**Waddington  
Parish  
Council**

Your ref. NC2/3/2016/0871

Planning App. No. 3/2016/0871 37 Ramsden Terrace,  
Clitheroe Road, Waddington, BB7 3HN

PROPOSED ELEVATIONS SEEN FROM ADJACENT PROPERTIES

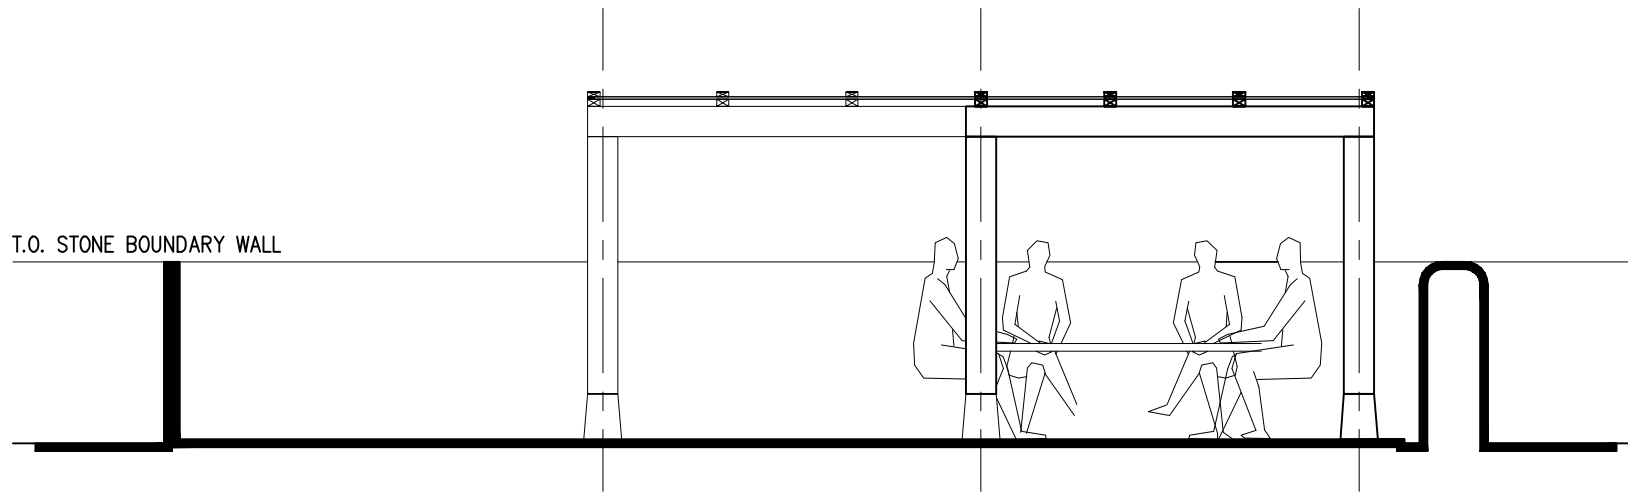
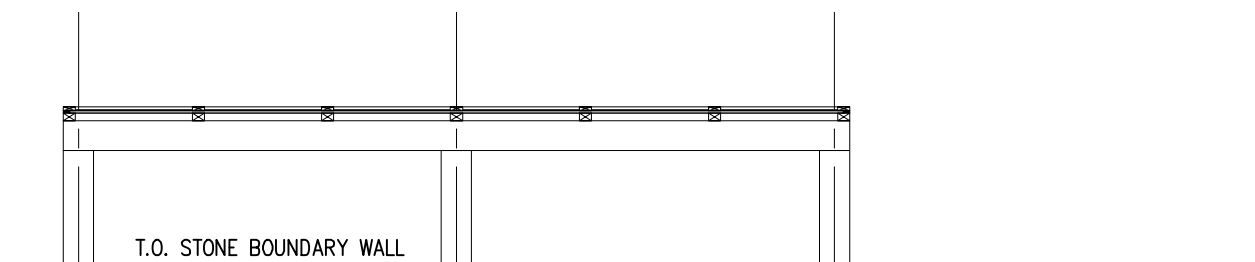
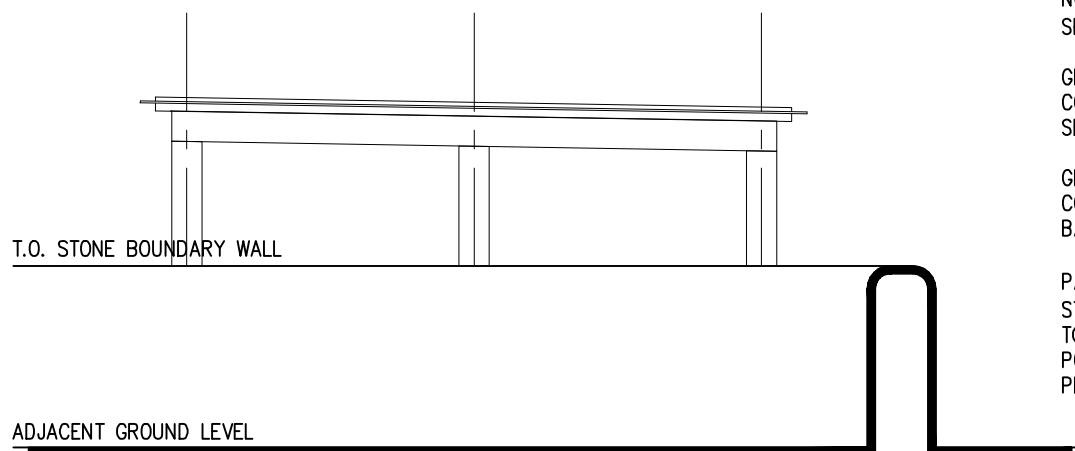
As you know Ramsden Terrace is in a Designated Conservation Area and the proposed covered pergola is completely out of character with the properties in this Area.

If approved a precedent would be made which would greatly adversely affect the appearance and attractiveness of the Area.
